From: Iqraa Ma [REDACTED]
Sent: 09 July 2020 [REDACTED]
To: Sian Eggington
Subject: FW: Request for further information AL/50/20/HH
Attachments: We sent you safe versions of your files; LPC - 01 Location and Block Plan.pdf; LPC - 06 Existing and Proposed first floor plans.pdf; LPC - 04 Existing Elevations.pdf; LPC - 03 Existing and Proposed roofplans.pdf; LPC - 02 Existing and Proposed floorplans.pdf

From: Kirsty [REDACTED]
Sent: 08 July 2020
To: Planning.
Cc: George Sa
Subject: Re: Request for further information AL/50/20/HH

Dwg no:	01 Location and Block Plan
Date:	07.07.20
Drawn:	KAH
Revision:	-

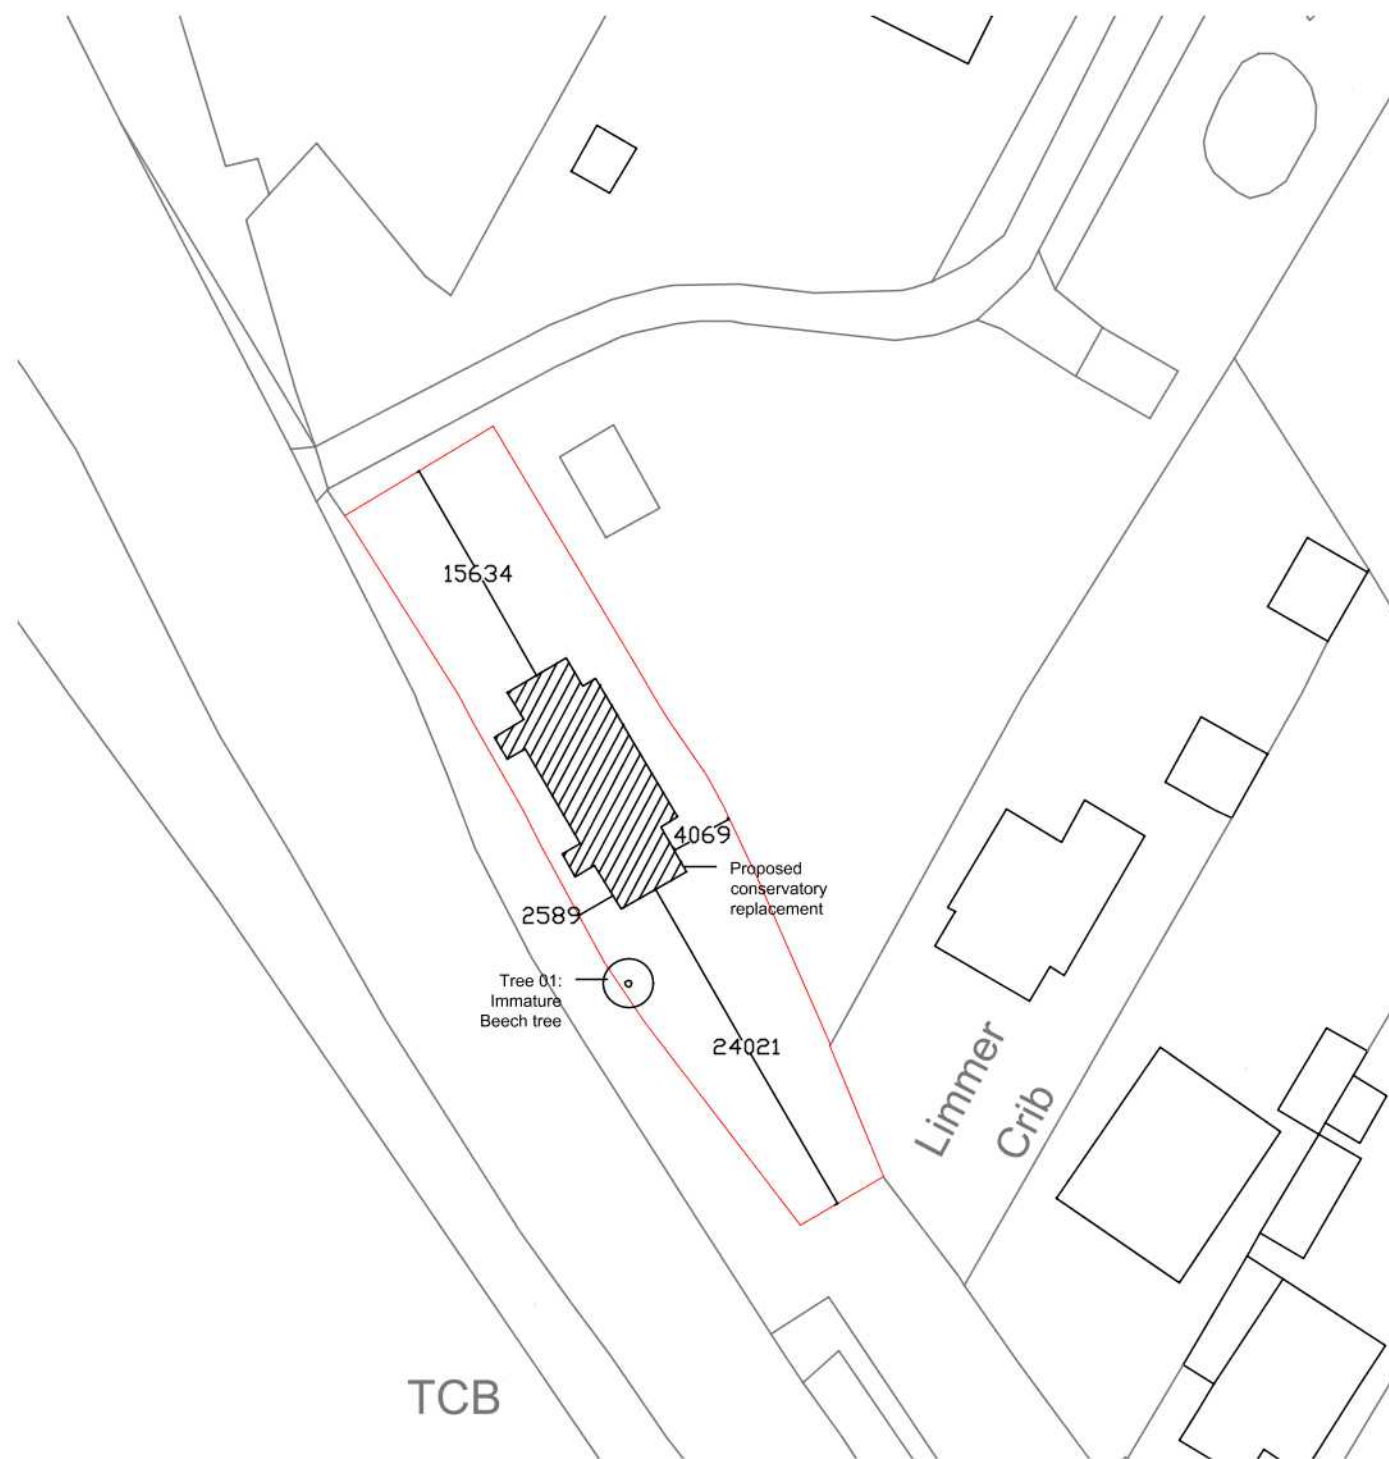
Please find attached amended Location and Block plan with site boundary dimensions and scale bars, labelled ground floor plan and new and labelled first floor plan and updated existing elevations with annotations (I have made no change to the proposed elevations drawing as this was already labelled; please confirm I have interpreted your request correctly?). Regarding the property address, Limmer Pond Cottage now encompasses what are marked as cottages 1 & 2 on your local authority mapping system; I believe this has been the case for the past forty years or so.

Dwg no:	03 Roof plans
Date:	07.07.20
Drawn:	KAH
Revision:	-

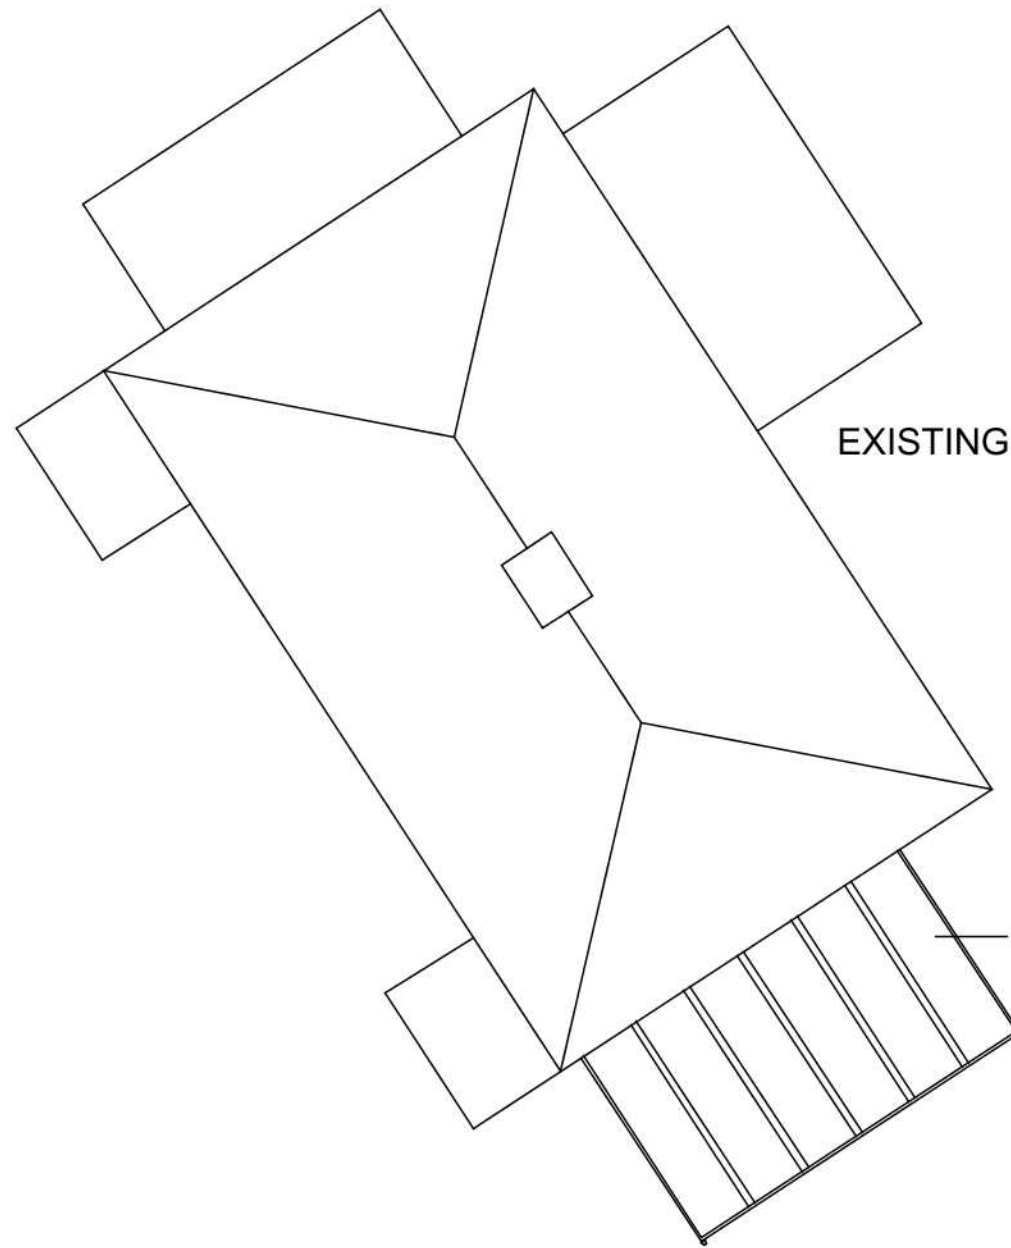
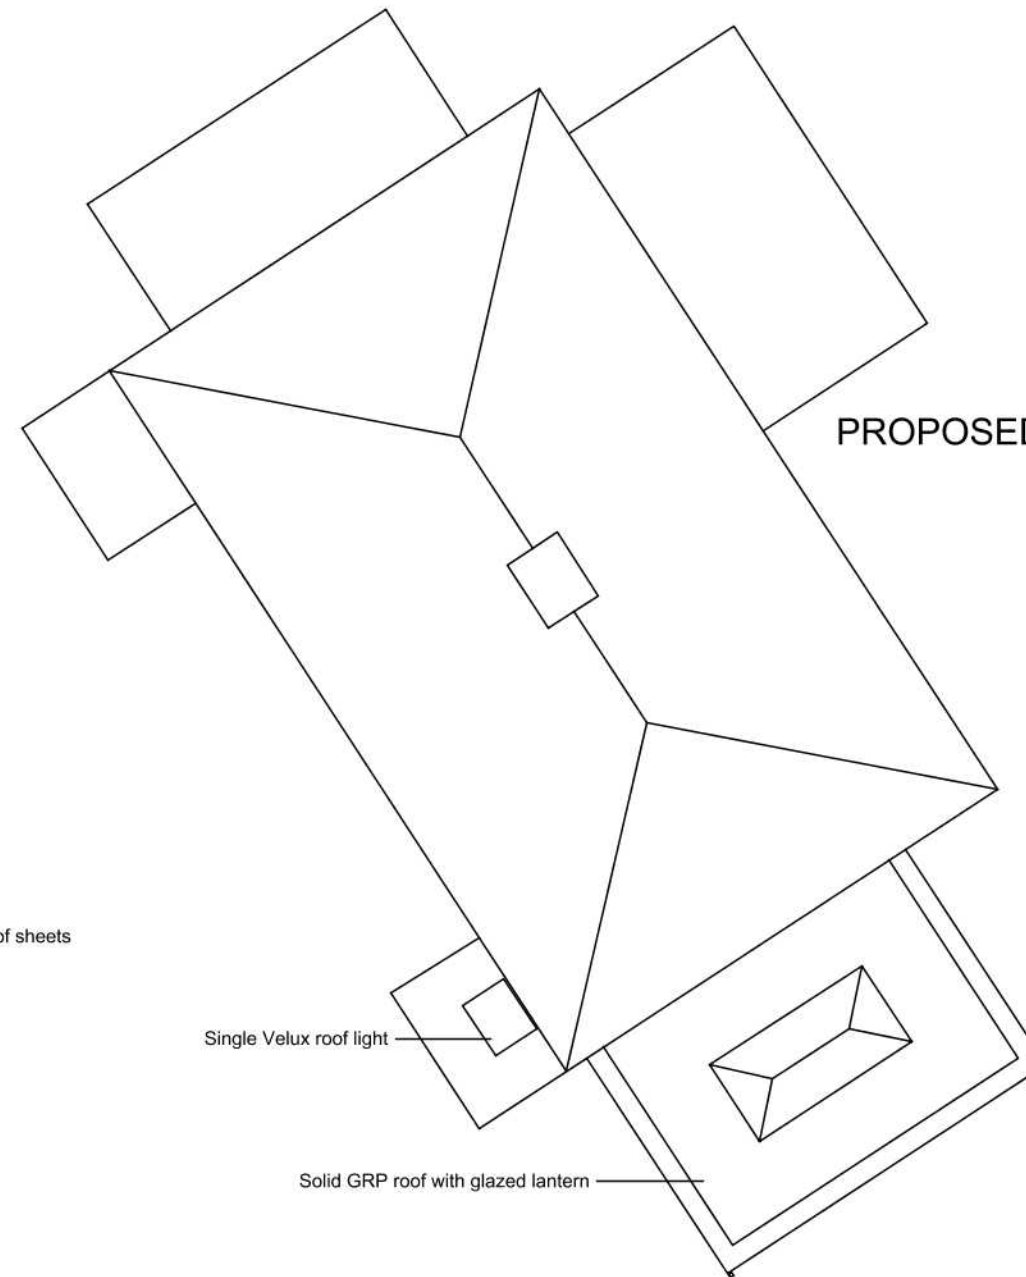
In addition to the above, I have updated the roof plan as the roof lantern wasn't in the correct position, hence I also attach this to this email.

Dwg no:	06 First Floor plans
Date:	07.07.20
Drawn:	KAH
Revision:	-

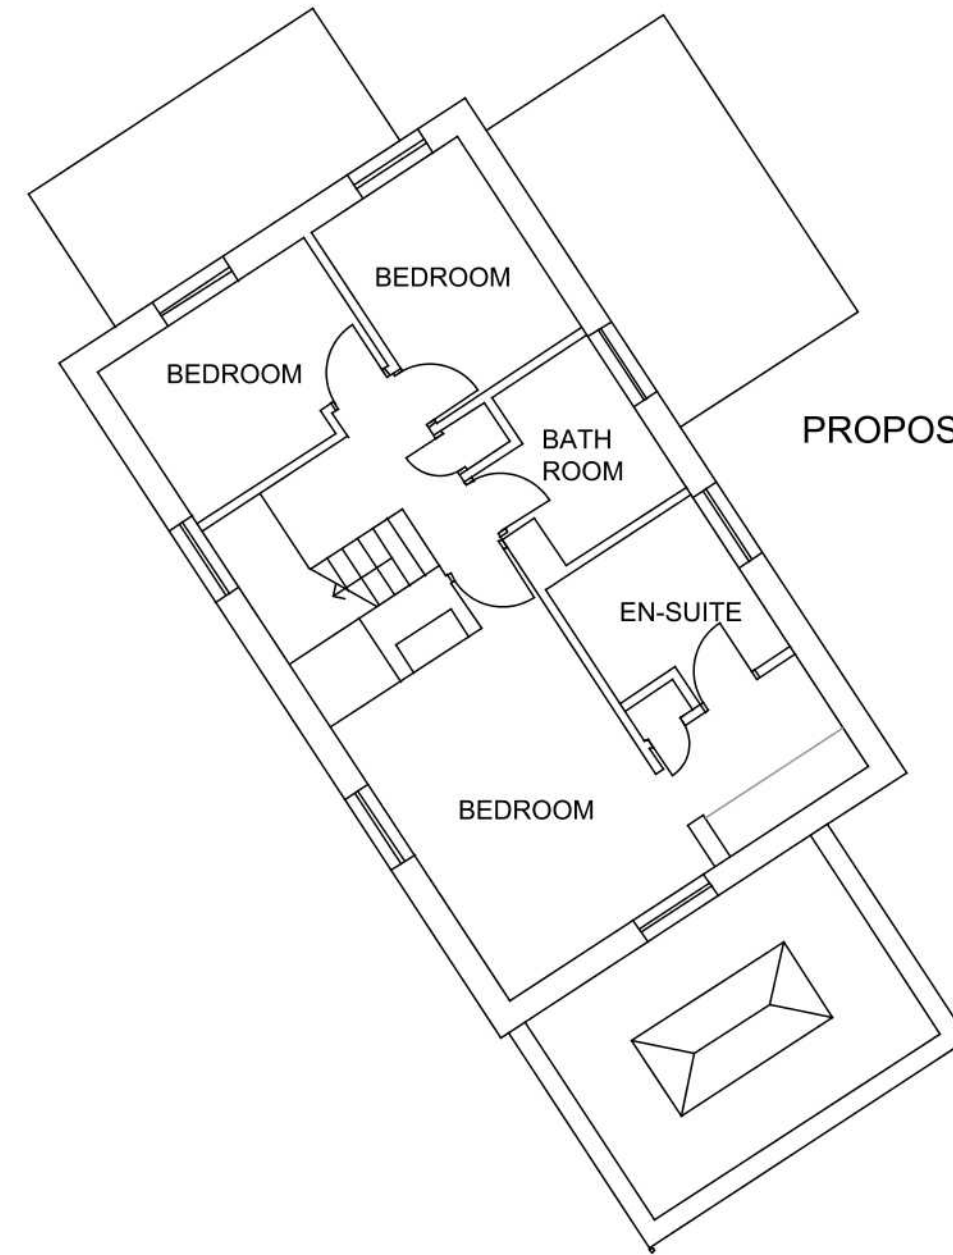
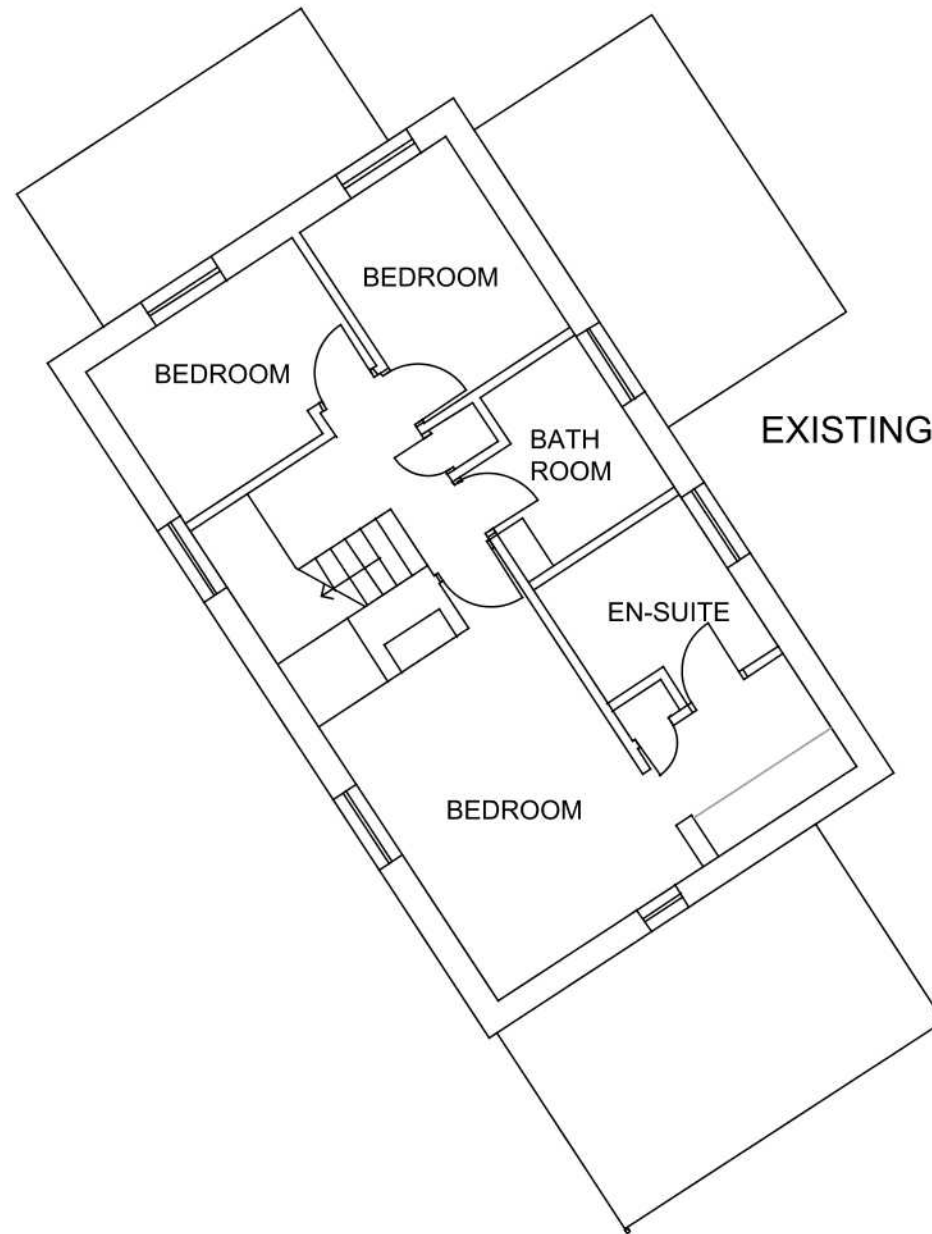
The first floorplan has been given the drawing title 06 for ease as the preceding drawing numbers are already listed in the written application form.
